From: Jonathan Best <Jonathan.Best@arun.gov.uk>
Sent: 19 February 2026 14:29
To: Planning.Responses <Planning.Responses@arun.gov.uk>
Cc: Hebe Smith <Hebe.Smith@arun.gov.uk>
Subject: FG/6/26/PL

Little Twittens Recreation Ground Sea Lane Ferring BN12 5DY.

I have reviewed this application with regards to ecology and Biodiversity Net Gain.

Onsite Habitat Plan | Symbology

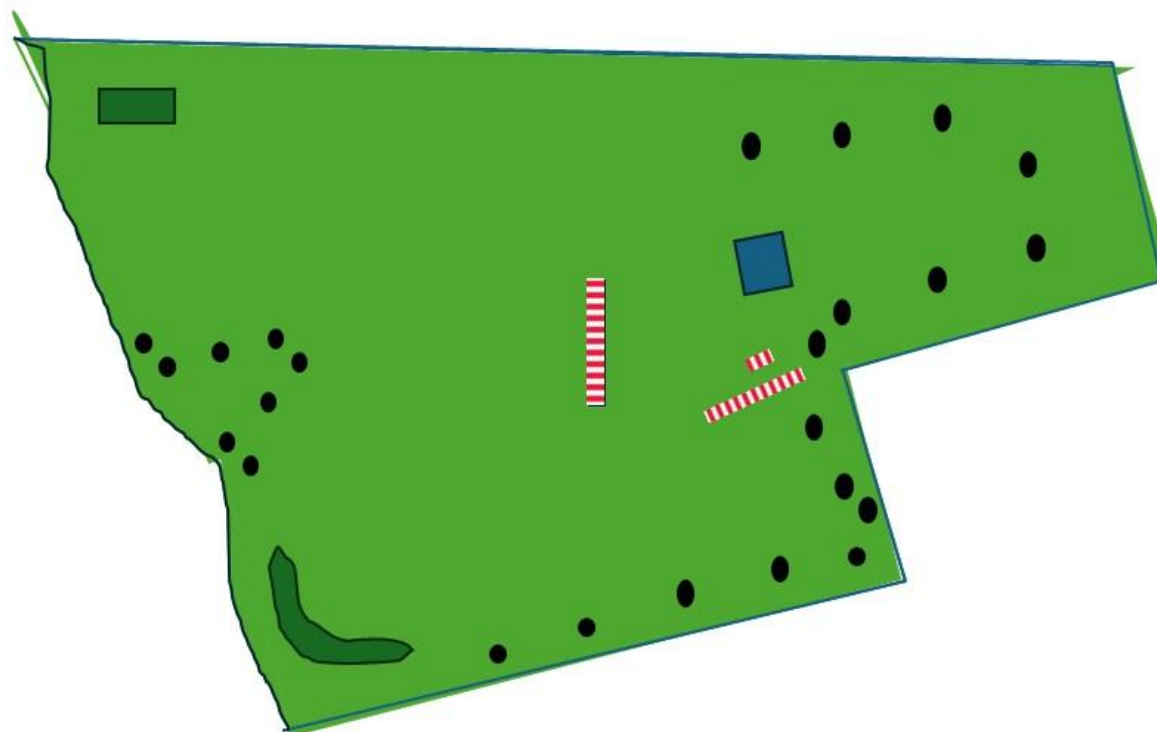
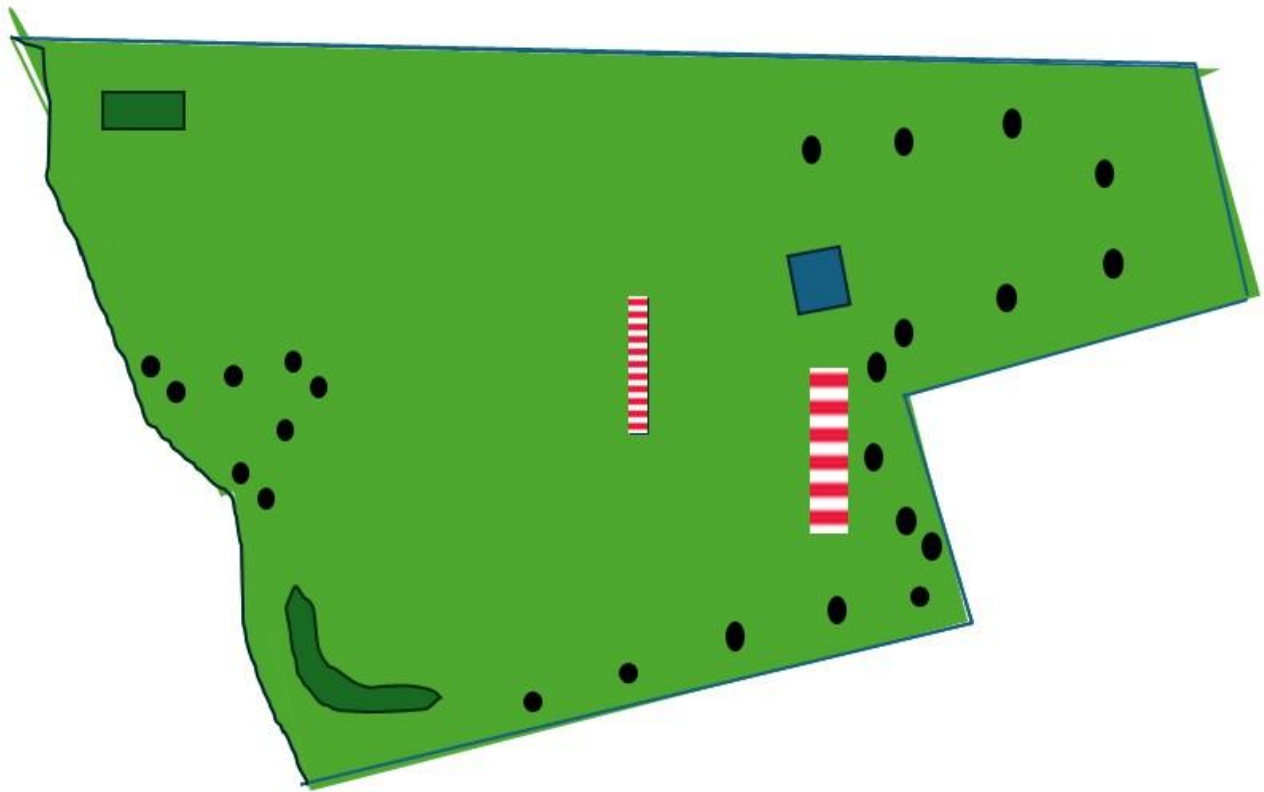
The habitat creation provided is for other neutral grassland. It is not clear on the habitat plans where this is located. The Net Gain plan states it consists of a 70m margin.
We will require a clear habitat plan when discharging the gain plan condition.

Other neutral grassland requires low nutrient conditions so a methodology of how this is being created would be required when discharging the gain plan condition.
